## **OXFORDSHIRE COUNTY COUNCIL'S RESPONSE TO CONSULTATION ON THE FOLLOWING DEVELOPMENT PROPOSAL**

**Application no:** 22/00959/REM

**Proposal:** Reserved matters application pursuant to outline planning permission 19/00963/OUT to discharge all remaining reserved matters (appearance, landscaping, layout and scale), the full discharge of conditions 1, 14, 17, 18 and 20 and the partial discharge of conditions 5, 7, 11, 12, 13, 19 and 23. The outline planning application was not subject to an environmental impact assessment.

**Location:** East Of Last House Adjoining And North Of Berry Hill Road Adderbury

BERRY HILL ROAD, ADDERBURY - DRAFT SITE LAYOUT

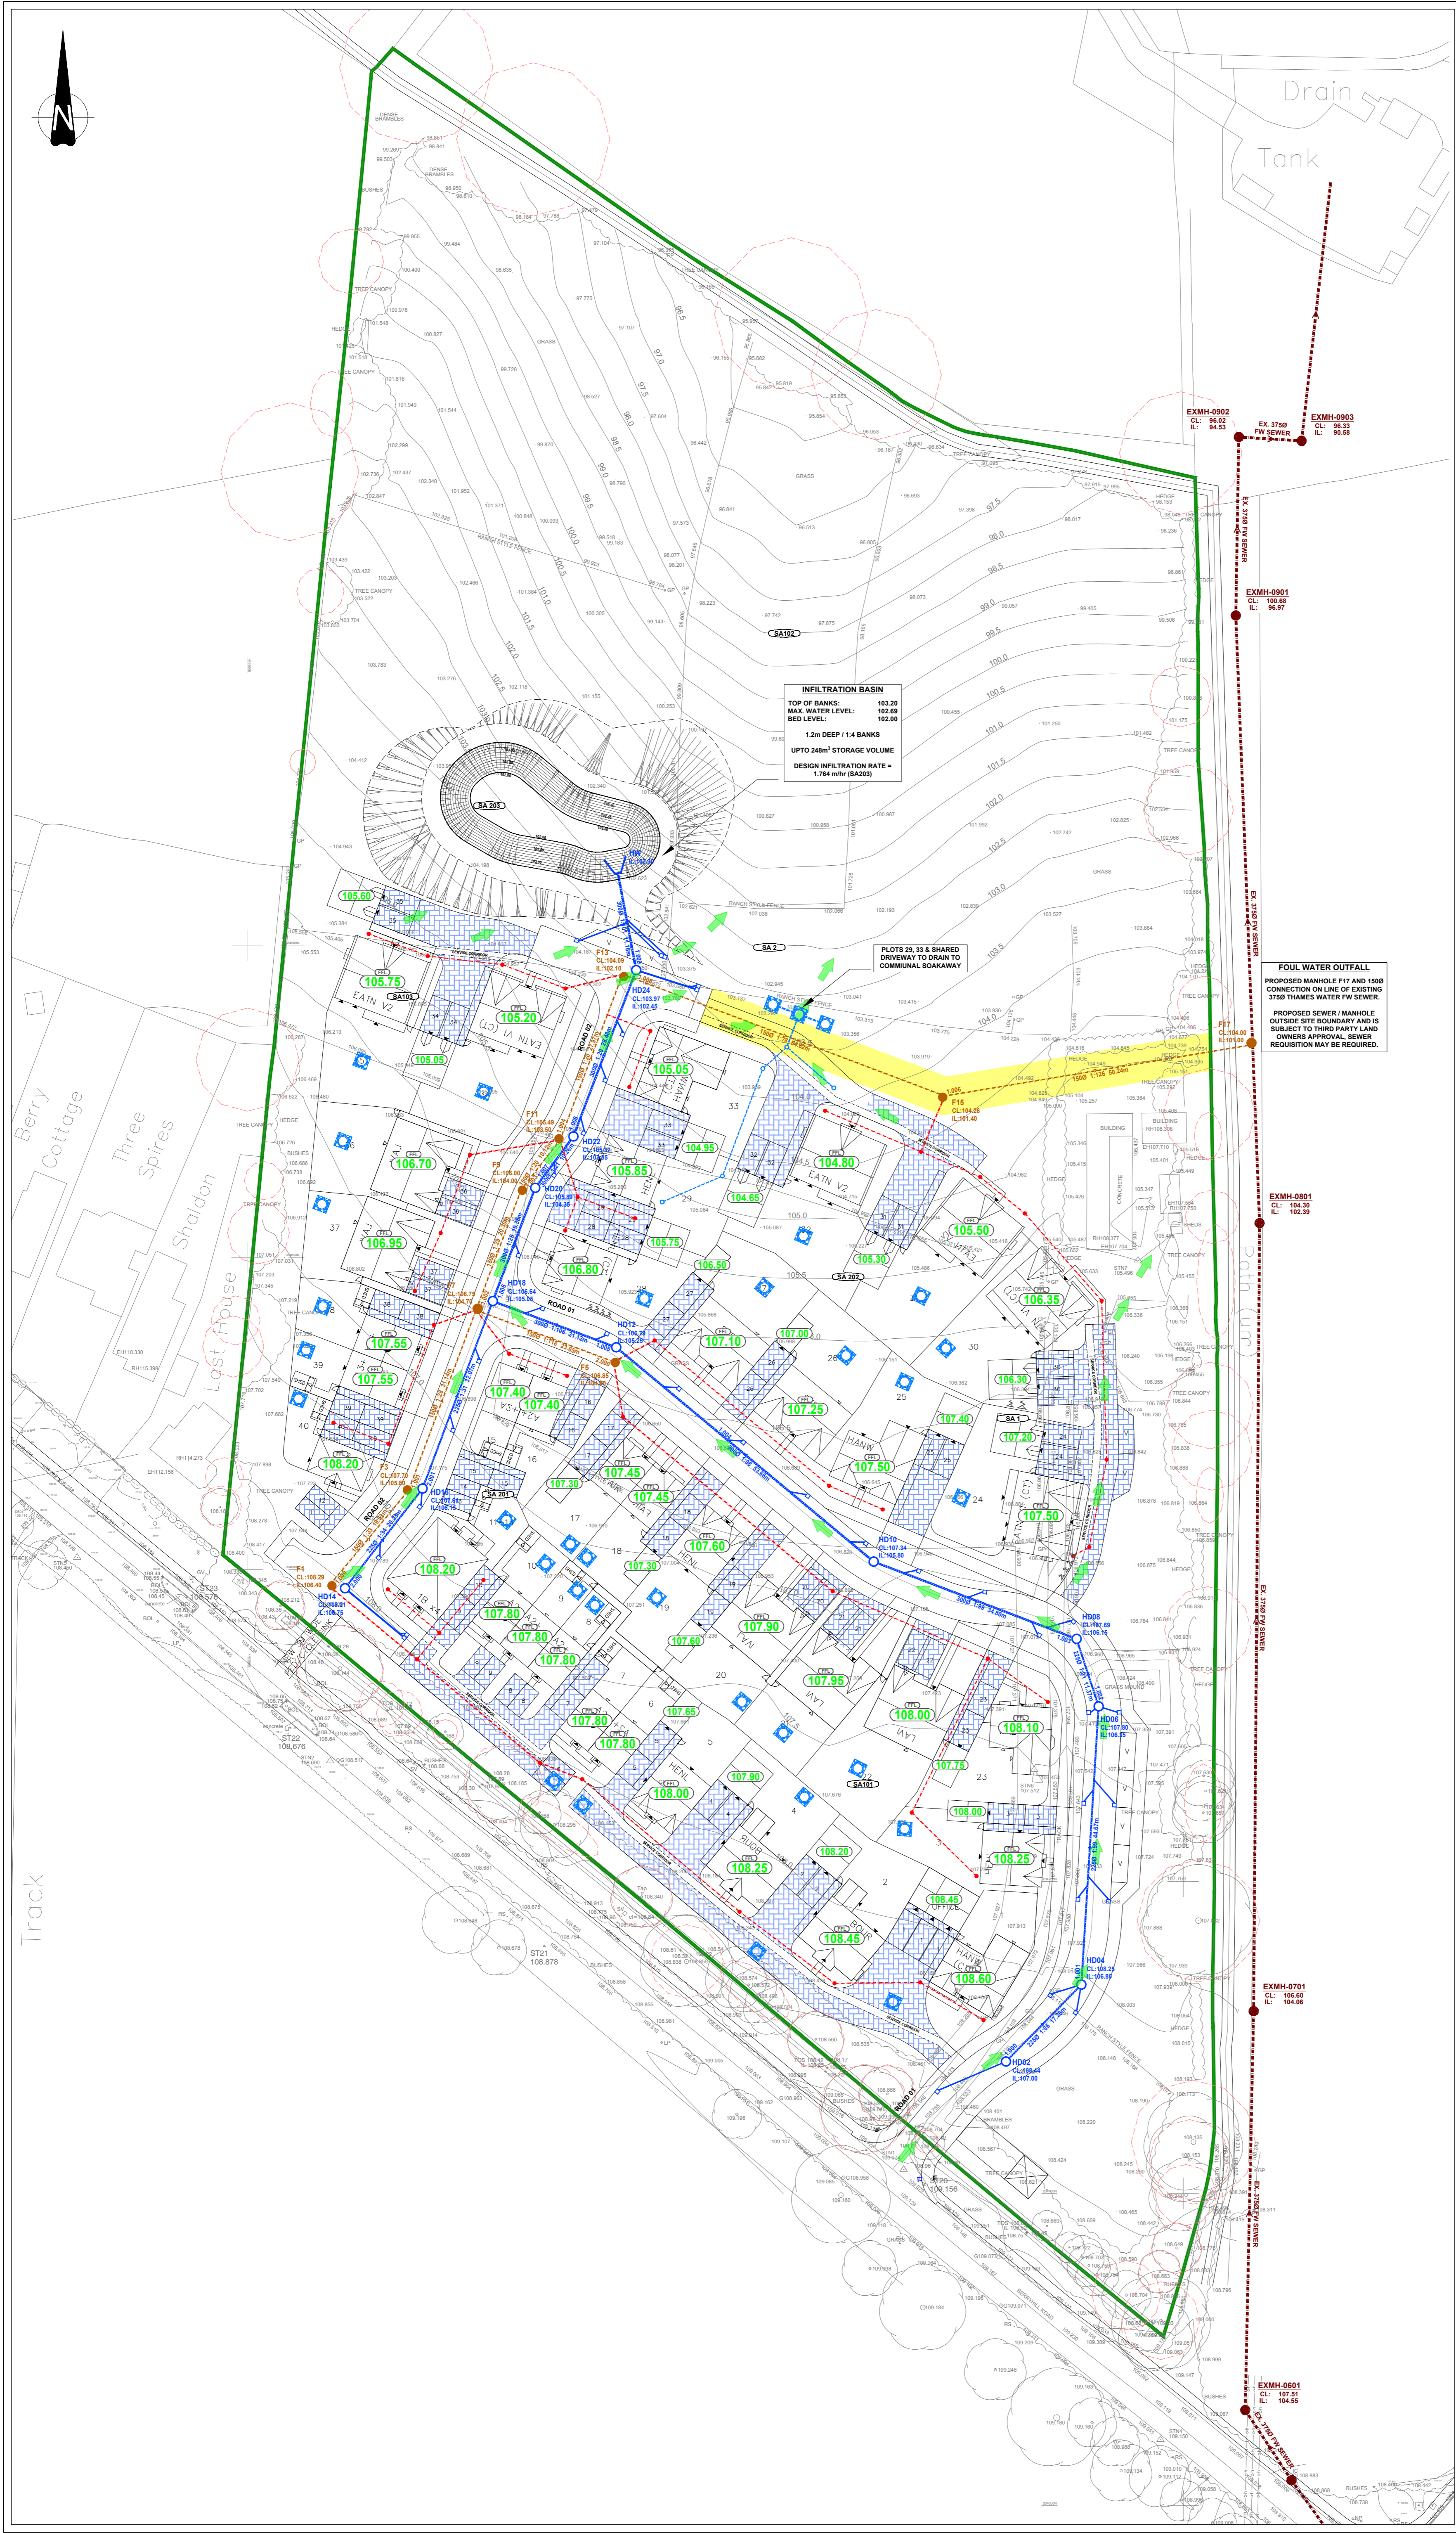
**Cycle Parking:** The properties that have a garage provided, have restricted access to them when the vehicles are parked in their designated spaces. Where access points have been provided, they do not conform to the minimum of 1.2m-1.5m needed for convenient cycle parking. Houses under 3 bedrooms have no cycle parking provided. Section 2.4 of the Oxfordshire Cycling Design Standards states that there should be '1 space for 1 bed unit, 2 spaces for larger units'.

**Footways:** There should be a 2m footway either side of the road where there are properties on both sides. This is to ensure both safety and accessibility for people living in all properties on the site.

**Landing Spots:** Where the section of 1:20 longitudinal gradient is present there will need to be flat landing spots.

**Visitor Parking:** The visitor parking spaces within this development do not conform to OCC guidance in relation to dimension. Parallel parking spaces should measure a minimum of 2.5m x 6m to accommodate for all private vehicles.

**Bin Stores and Refuse Collection Points:** Details of bin storage or refuse collection points have not been detailed by the applicants. An area for bin storage must be identified on every property to ensure there is adequate space and demonstrate that they are not going to spill onto the highway. Refuse collection points will be needed at the end of each private drive as a refuse truck will not drive into these areas.

There is currently insufficient footway provision within this site. There should be a 2m footway on either side of the road where there are properties on both sides. This is to ensure the safety and improve the accessibility for people living in all properties within the development.

Where the section of 1:20 longitudinal gradient is present there will need to be flat landing spots. OCC's inclusive mobility guidance states that 'even if there not a pedestrian route in excess of 1:20, it is important that there are level sections or landings at regular intervals to provide people with an opportunity to rest.' A level landing must be provided for every 500mm that a route rises.

Property 1 has been allocated 3 designated vehicle parking spaces as well as a garage, as mentioned above, this will need to be addressed. However, when assessing the site layout, they are blocking the sales office access points. I would therefore recommend that the layout of this parking is revisited to ensure the offices are more accessible for all users.

The dimensions and the amount of visitor parking is insufficient when referring to OCC policy. OCC's Parking Standards for New Developments states that parallel parking bays should measure a minimum of 2.5m x 6.0m for safety and manoeuvrability, the spaces within this development only measure at a width of 2.0m. Within OCC's draft for

- A section 278 application will be required for the access works.
- It is not clear if the access arrangement track as the kerbs have not been indicated.
- Where the section of 1:20 longitudinal gradient is present there will need to be flat landing spots.
- Adoptable visitor parking bays must be 2.5m in width.
- There should be a 2m footway either side of the road where there are properties on both sides.

- There are no visibility splays indicated. Junction and Forward Visibility Splays and dimensions must be in accordance with the OCC Street Design Guide and dedicated to OCC if they fall out of the existing highway boundary.

BERRY HILL ROAD, ADDERBURY - LAVINGTON V1 ELEVATIONS AND FLOOR PLANS

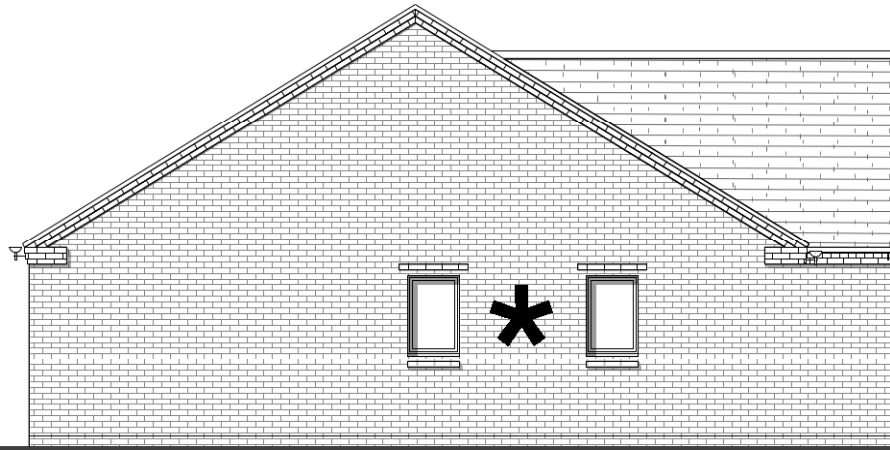
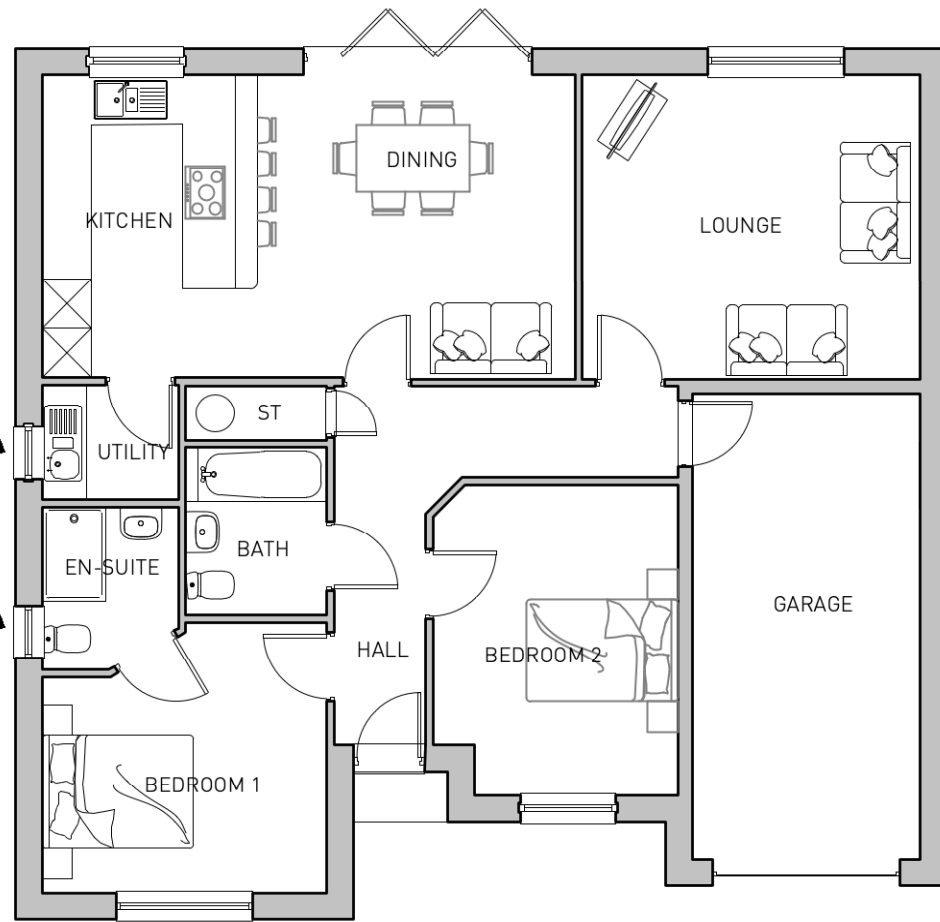
As mentioned above the Lavington, A1, A2 and A3 houses have all been designed without a garage and subsequently without cycle parking. It is stated within the OCC minimum parking standards that all new properties must allocate a certain number of cycle parking spaces per property. A1 properties should be allocated a minimum of 1 cycle space per property, with Lavington, A2 and A3 properties being allocated a minimum of 2 cycle spaces per property. Manual for Streets Chapter 8.2 states ‘Providing enough convenient and secure cycle parking at people’s homes and other locations for both residents and visitors is critical to increasing the use of cycles. Therefore, this issue needs to be addressed. Cycle parking should also be covered and secure, this is addressed by the cycle parking condition within the conditions section.

BERRY HILL ROAD, ADDERBURY - STRATFORD ELEVATIONS AND FLOOR PLANS

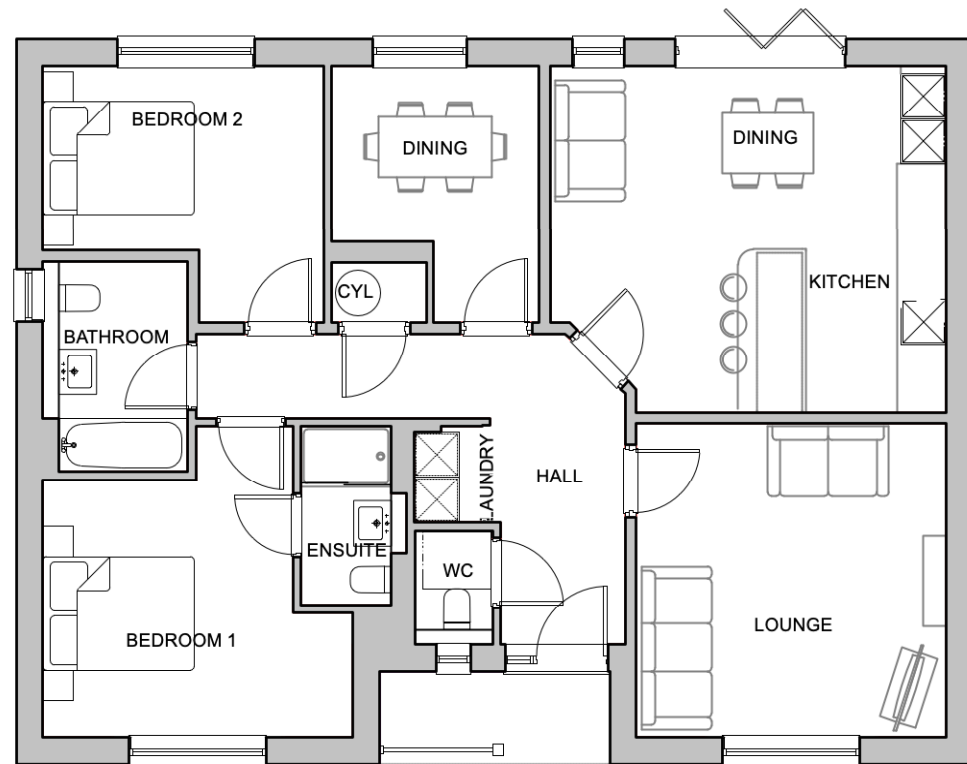
The 3-bed properties within this development (Stanton, Stratford, Fairford) have been designed with a garage measuring at approximately 3m x 6m. When referring to OCC's Parking Standards for New Developments it states that for a garage to classify as a vehicle parking it must measure 3m x 6m. Using this information and referring to OCC's maximum parking standards, the above-mentioned properties exceed the maximum number of allocated parking spaces for 3-bed properties. I would therefore recommend that the garage is reduced in size, removing its classification as a parking space, or design them in a way that makes them exclusively for cycle parking and general storage. In addition to this, properties 22 and 31 have been allocated 3 spaces as well as a double garage. Again, when referring to the OCC parking standards, this exceeds the maximum number of spaces permitted for a 5-bed property and will need to be addressed. The concern here is that this leads to a 'car based' development, where car use is encouraged as the most convenient and desirable option of travel, something OCC is trying to shift away from.
